**Re: Objection to MP08\_0244 MOD 1 Modification Request for Mixed Used Development at 23-37 Lindfield Avenue and 11 Havilah Lane, Lindfield**

As a resident of Lindfield, I/we wish to lodge an objection against the proposed Modification of the subject development based on the following grounds:

1 SHADOW DIAGRAM - 21stDEC_9AM
5003 SCALE1 : 650

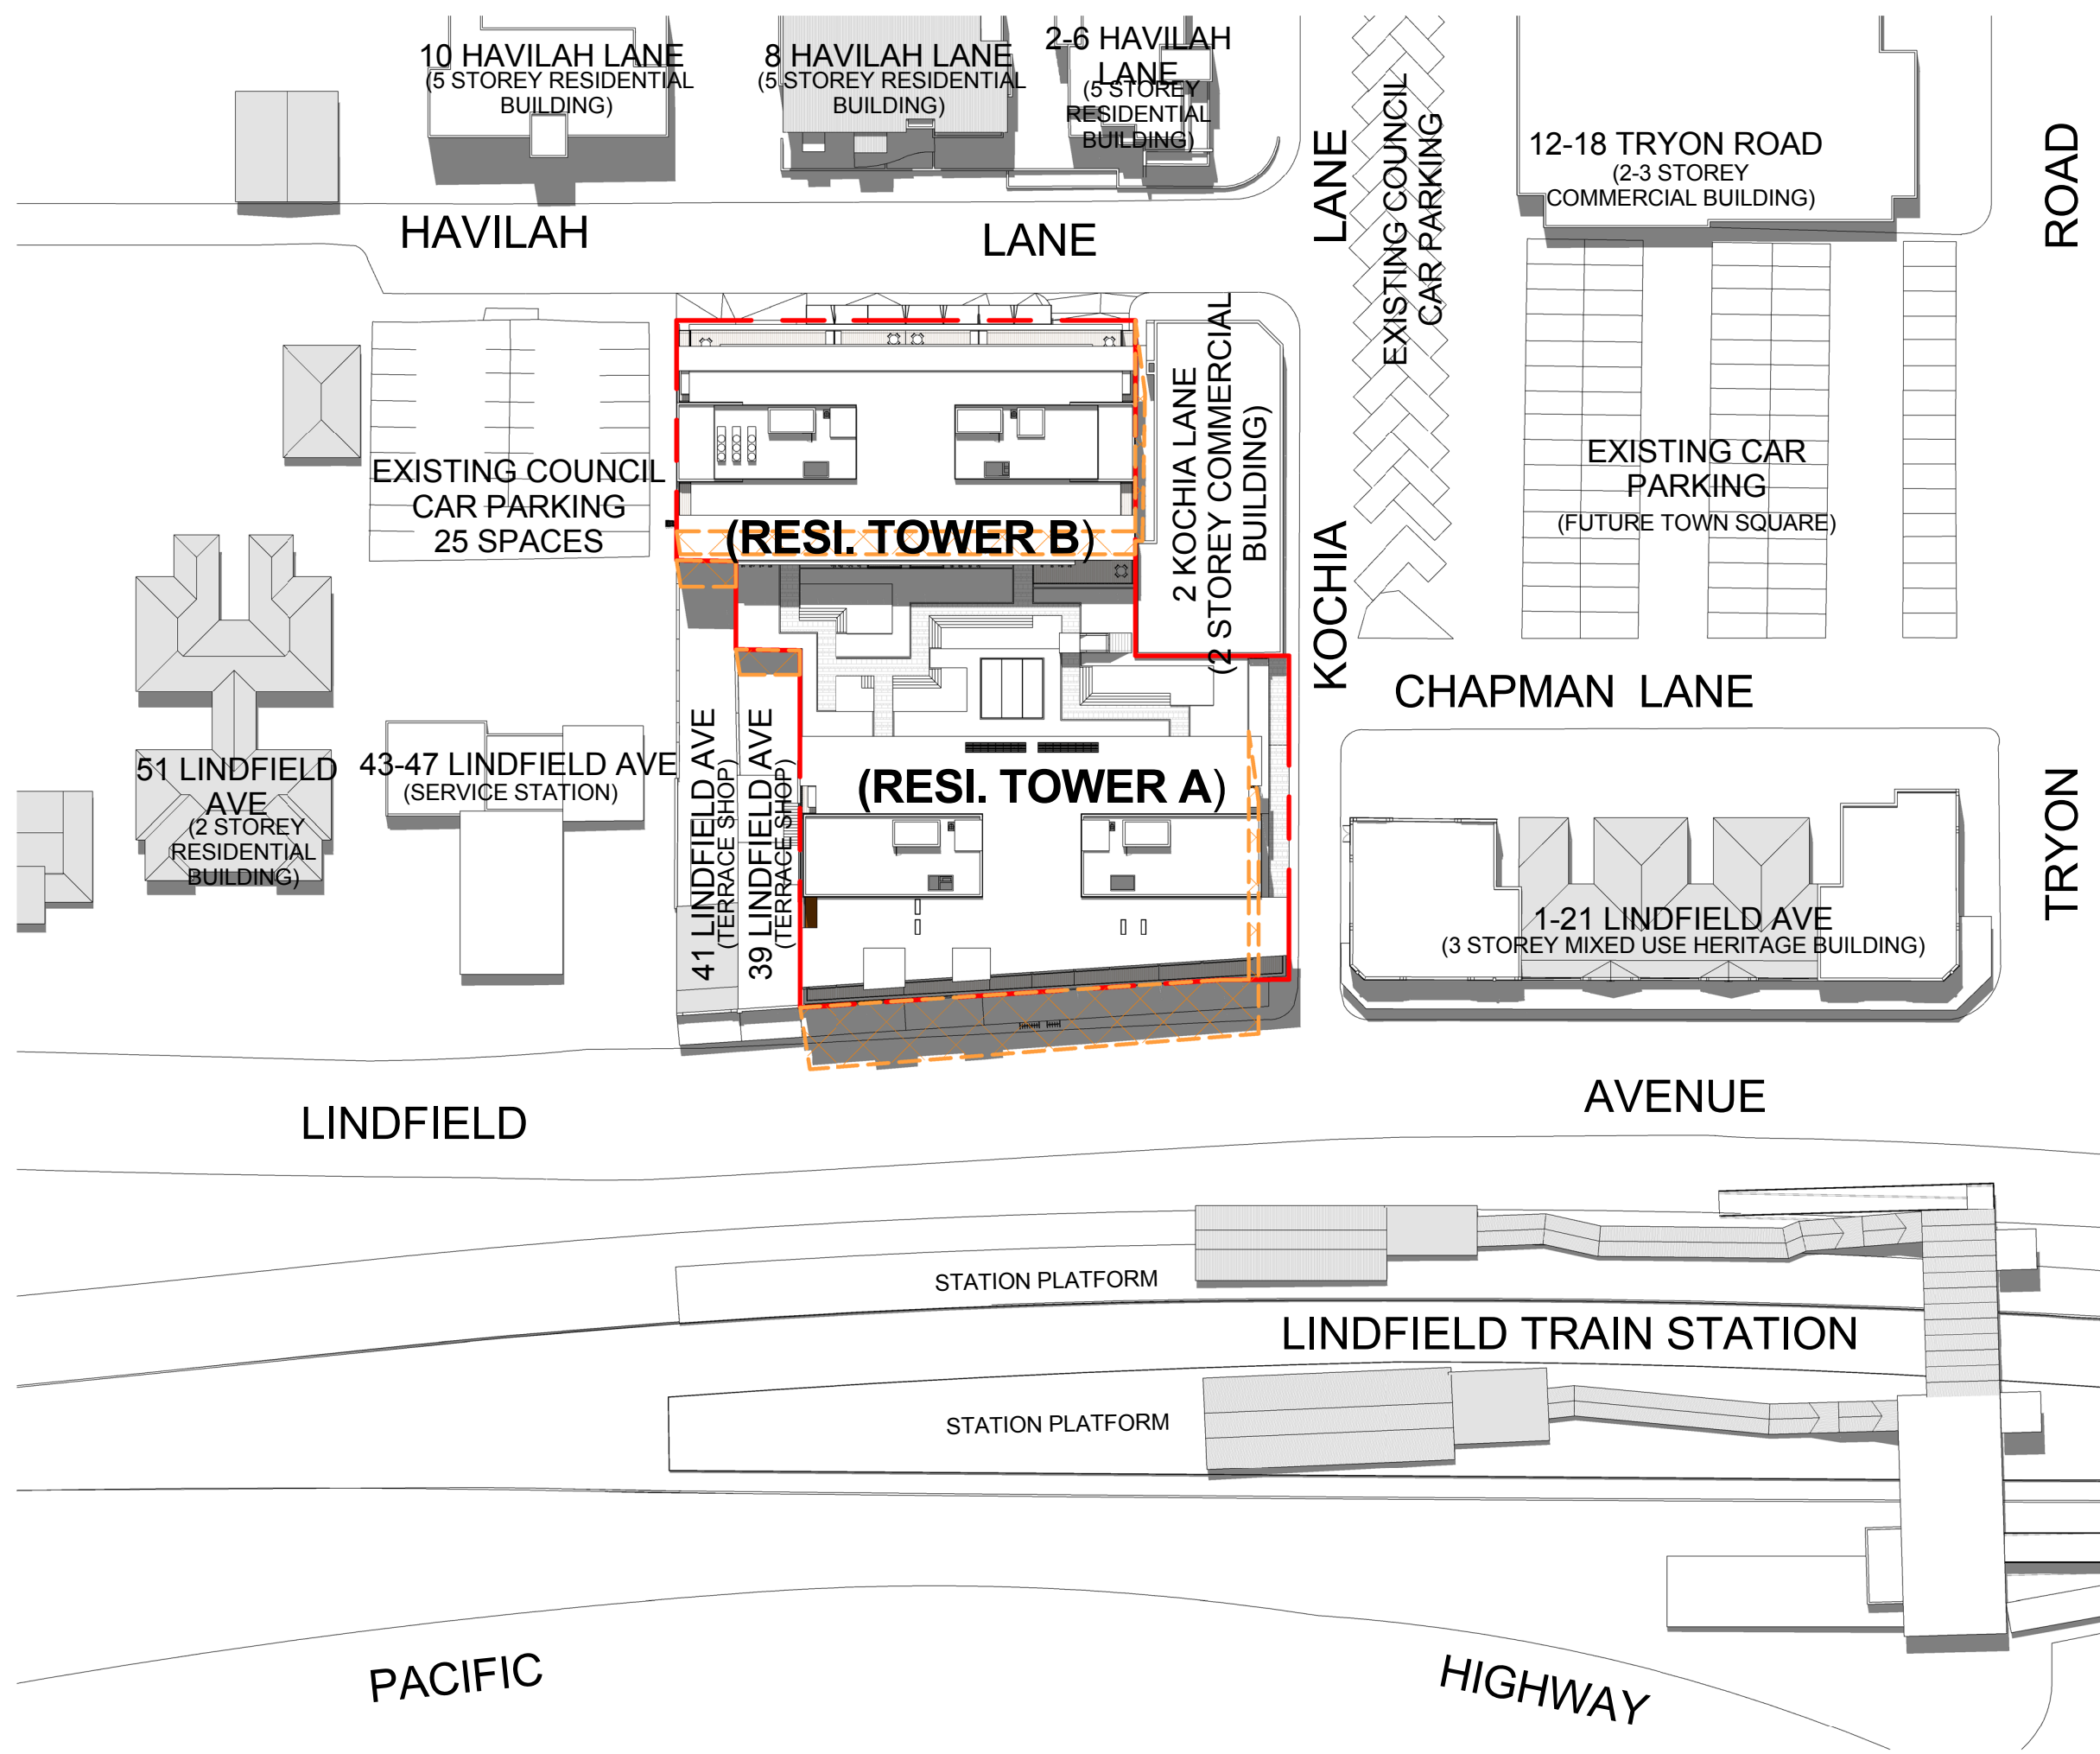
- The additional storeys create new adverse shadowing: a) for residents in the Havilah Lane apartments, particularly after 3pm b) for the popular outdoor café and central Lindfield hub area at 12 Tryon Road in afternoons, particularly in winter and c) for all commuters on the city bound Lindfield rail platform, instead of 50% of the year as approved, it will now be in shadow in the mornings 75% of the year

FIGURE 1.3 – MODIFIED SCHEME CAR PARKING

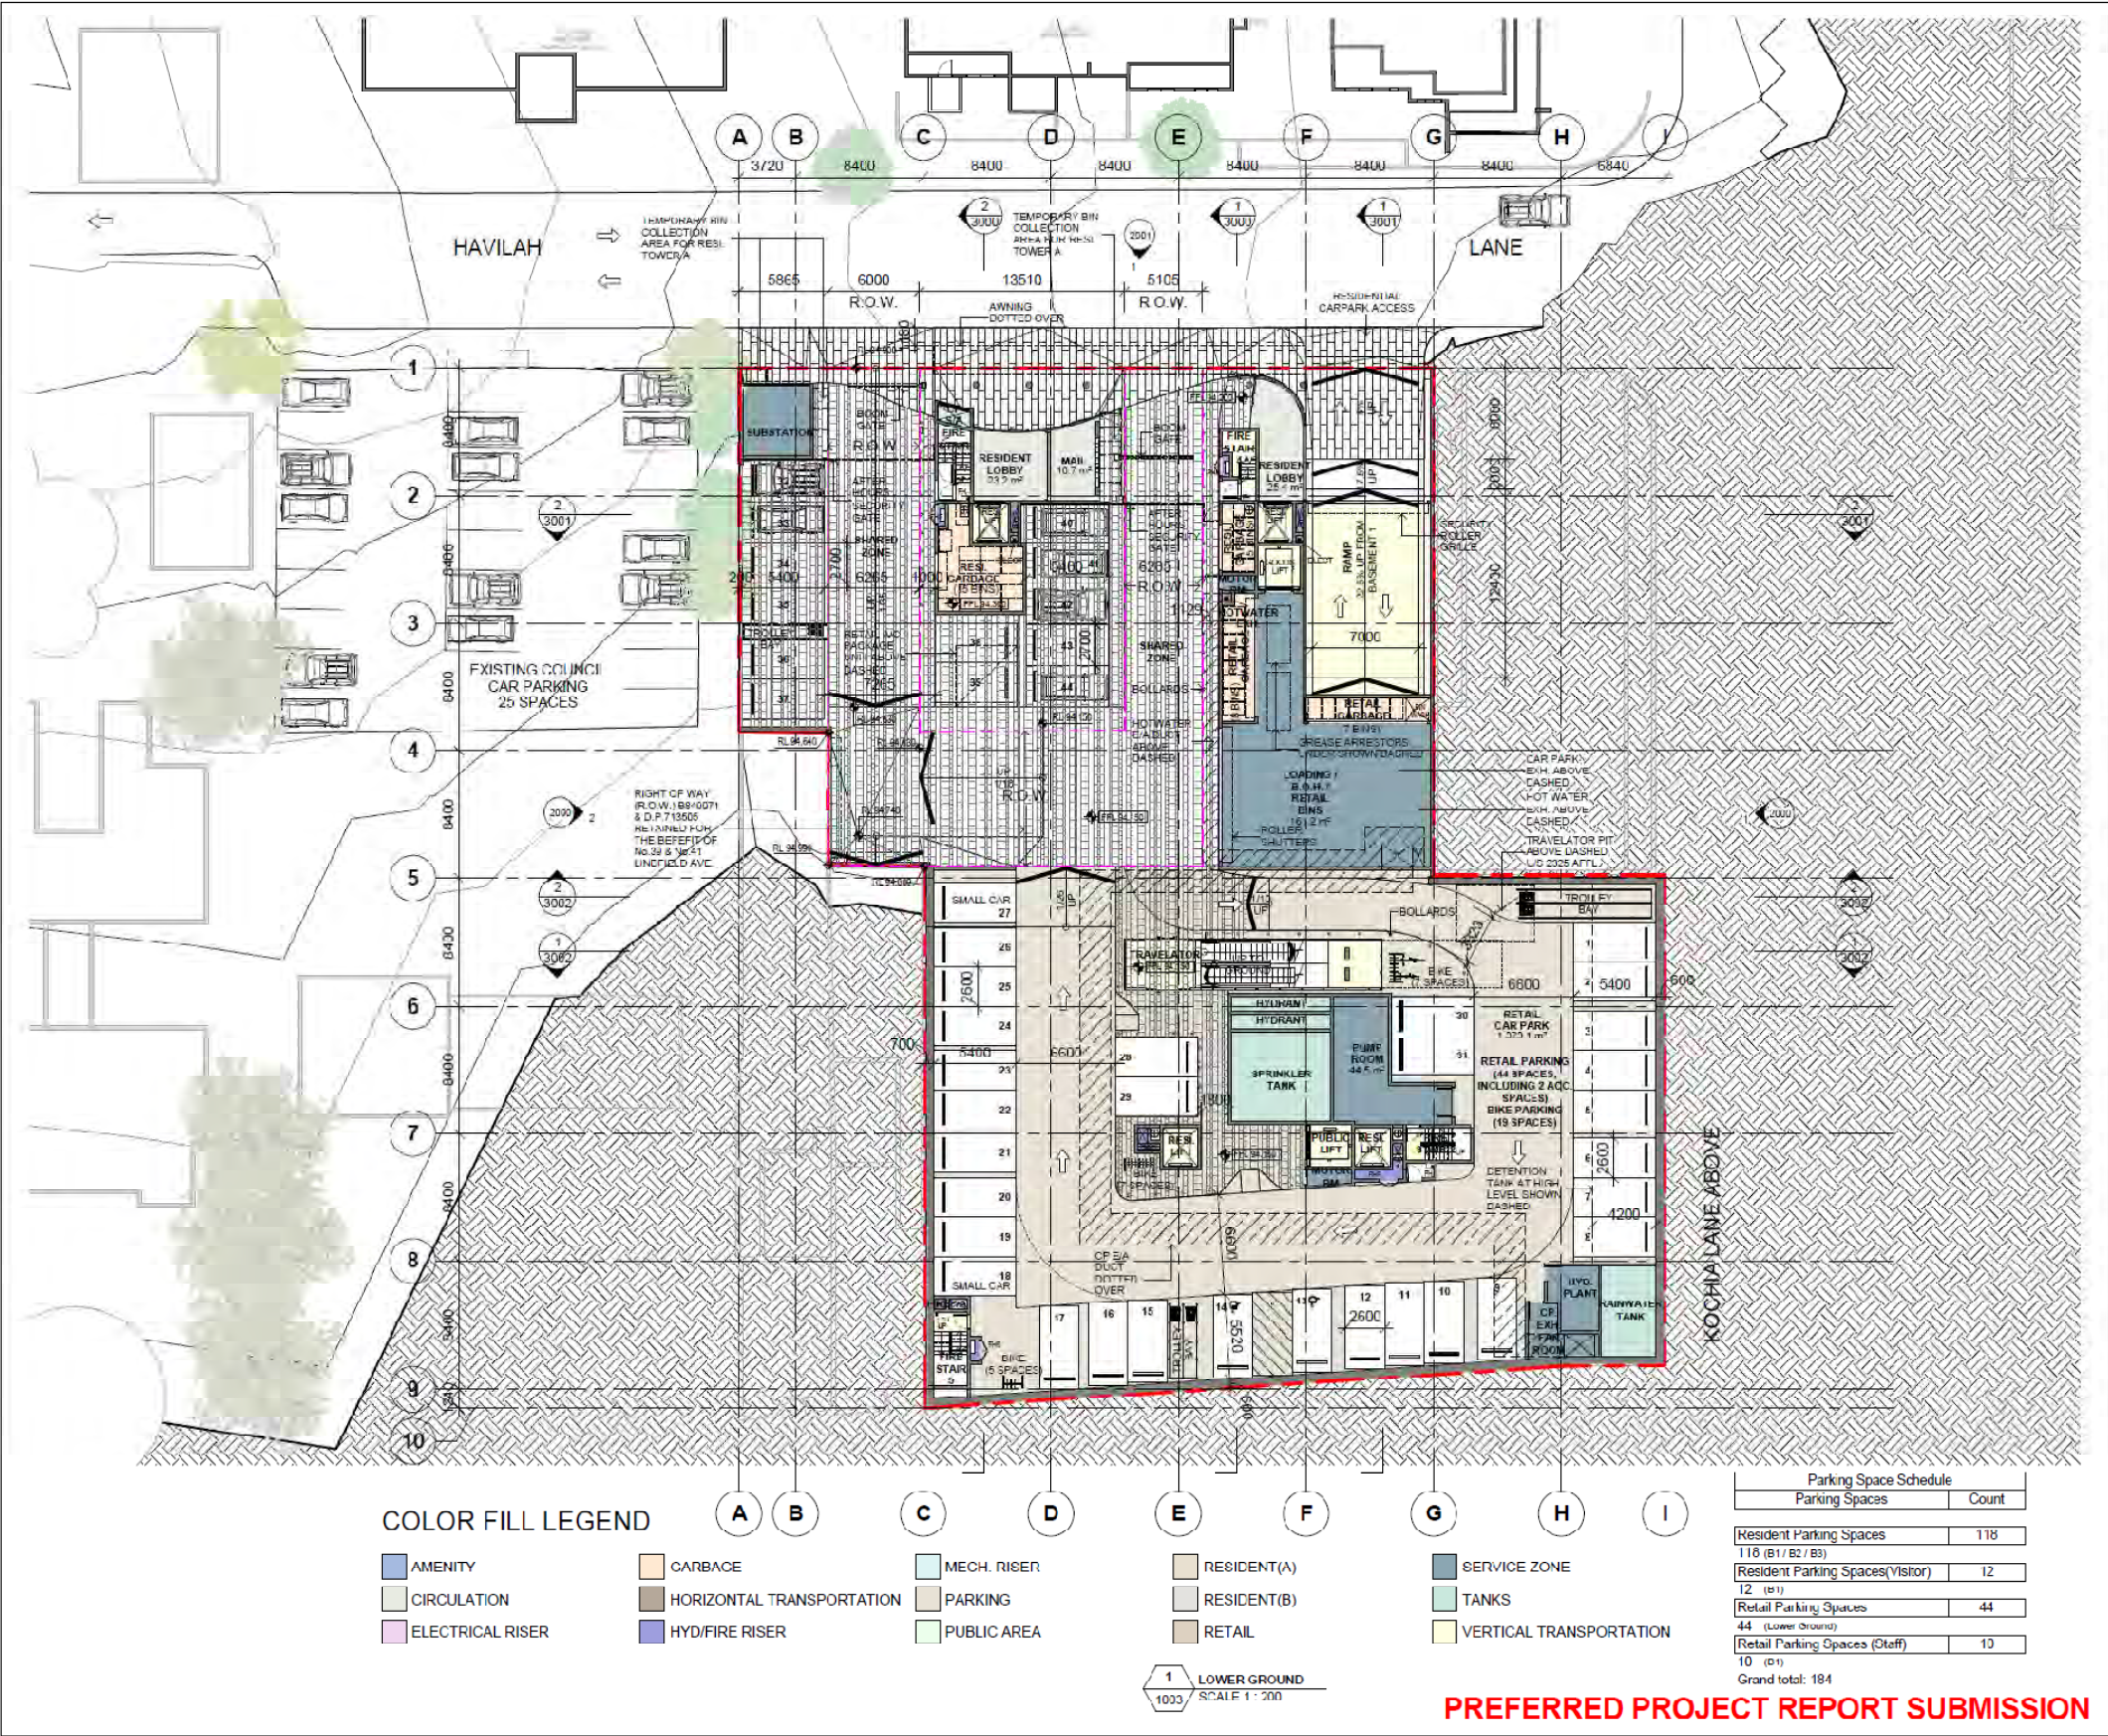
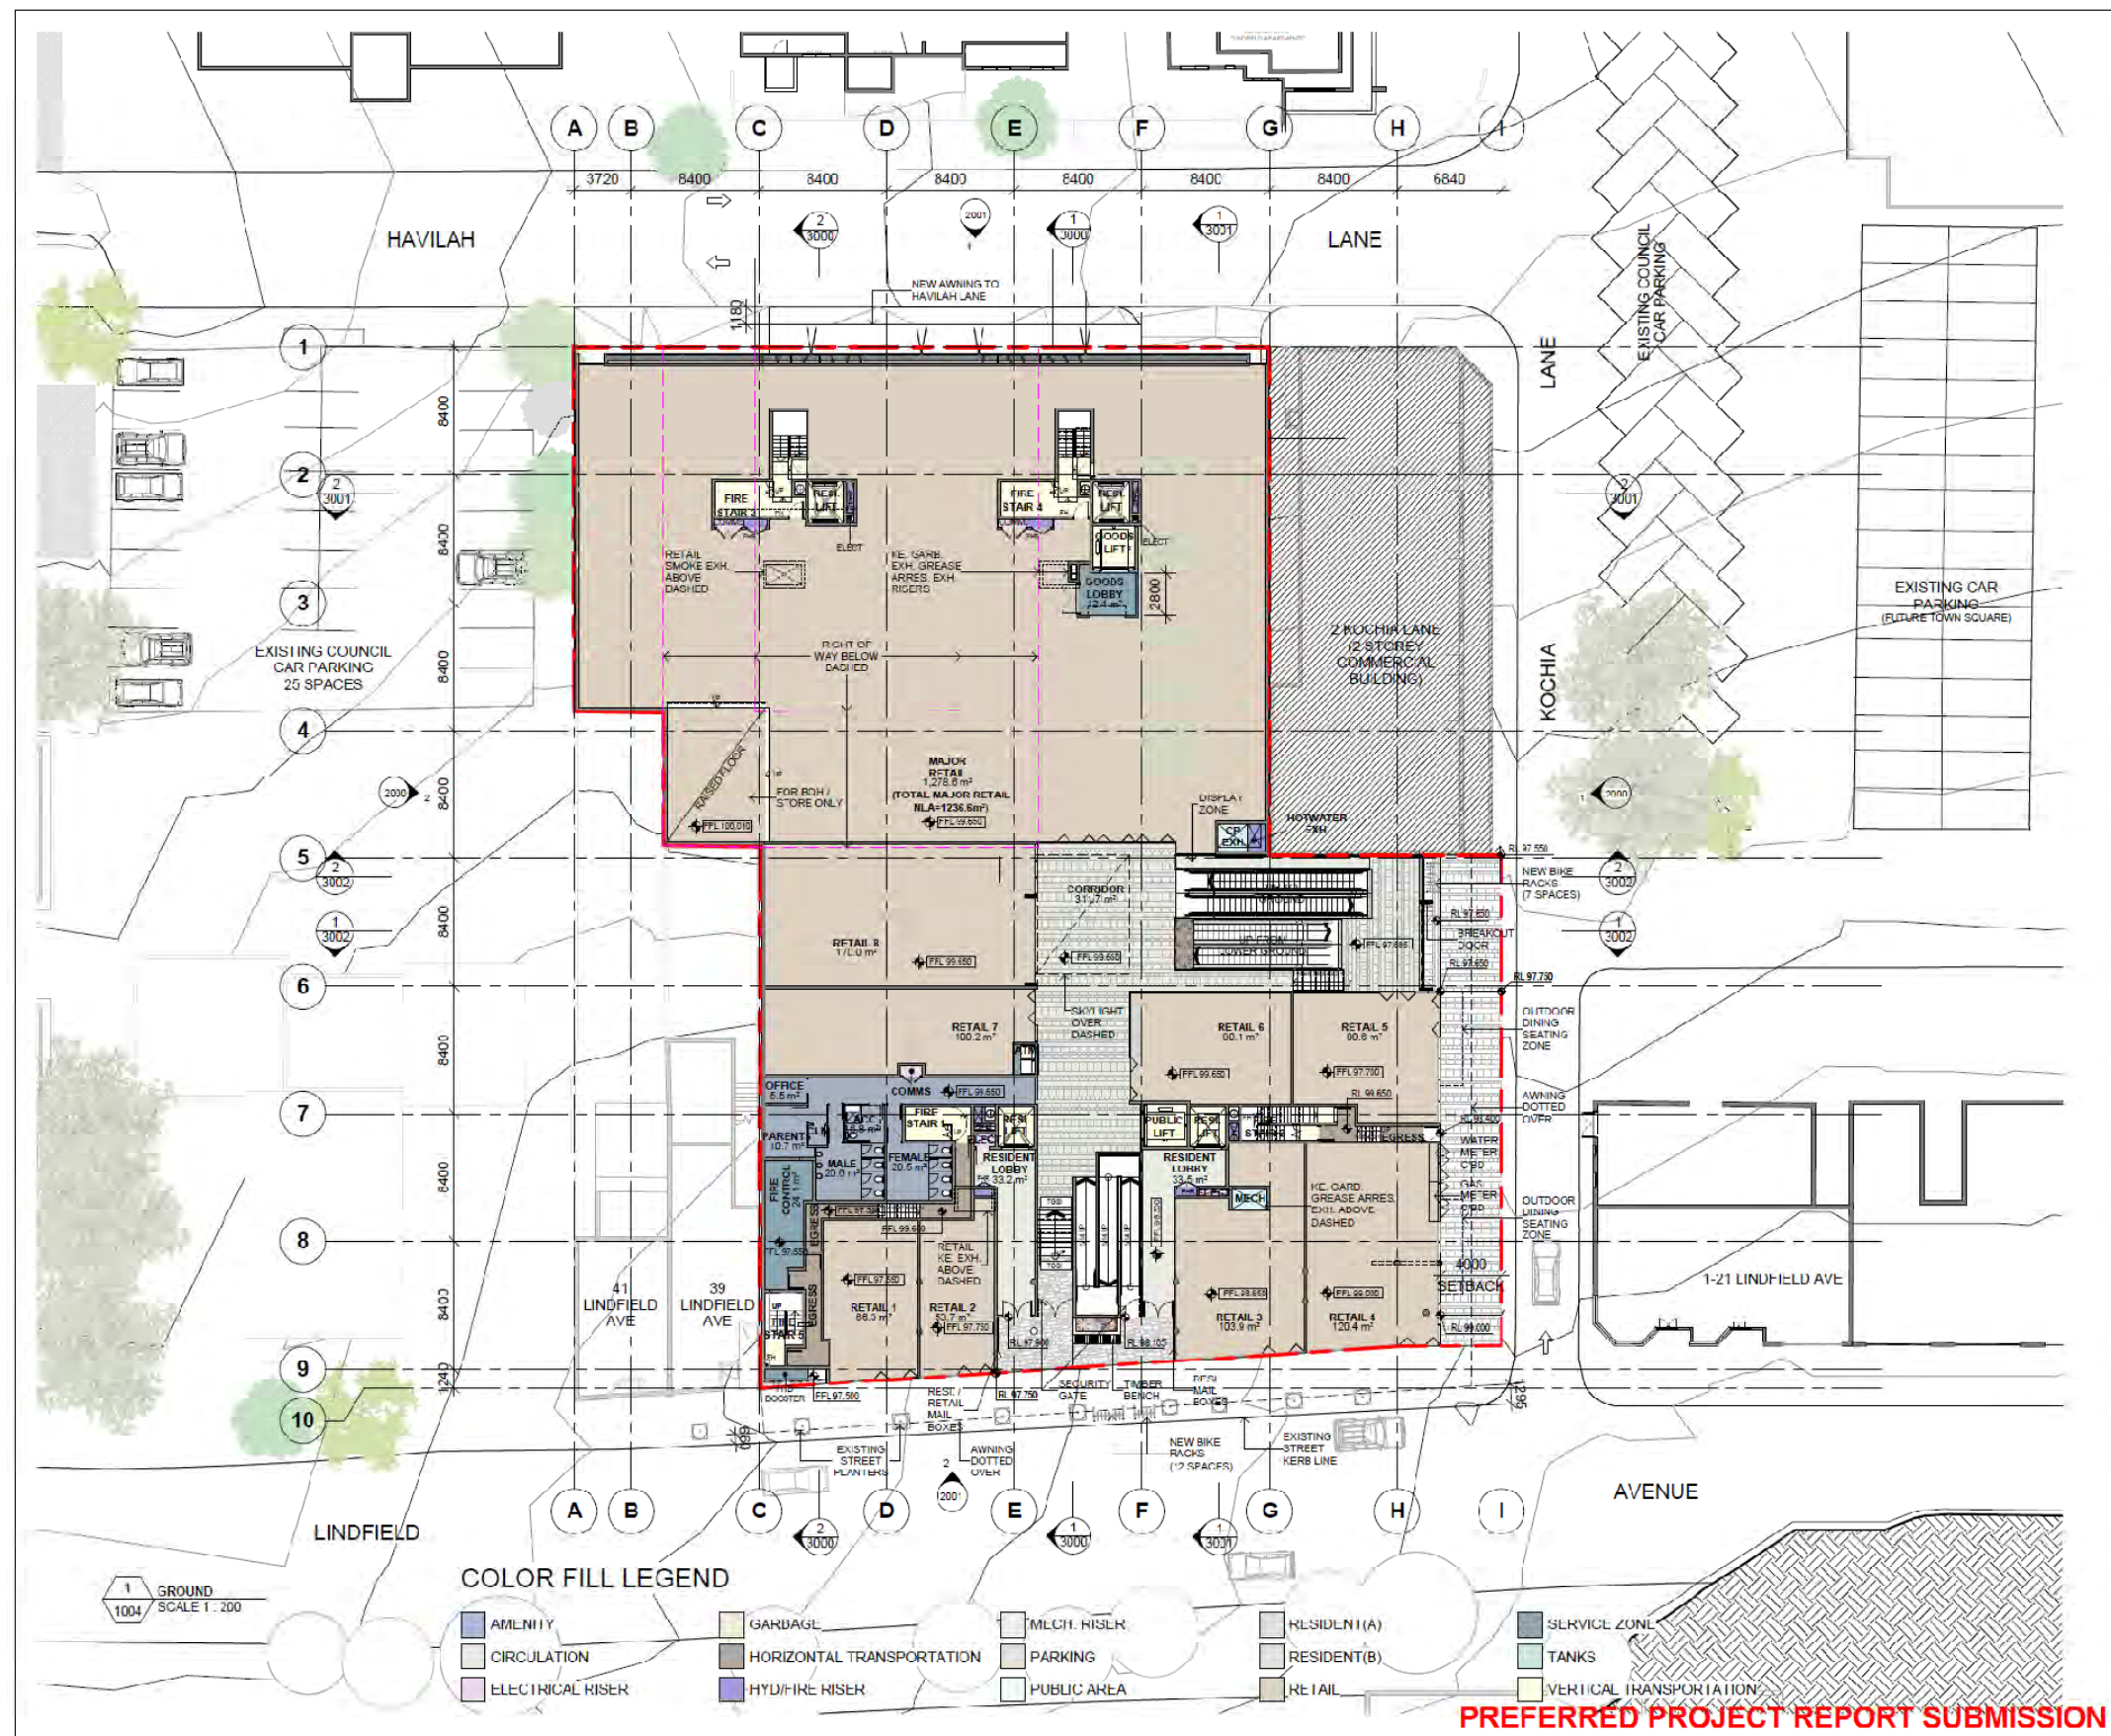
- Car spaces were identified as inadequate for the retail component and this has not been addressed relative to the remaining retail space proposed. The 25 car spaces counted as part of council's car park are also now highly uncertain due to the proposed rezoning and potential redevelopment.
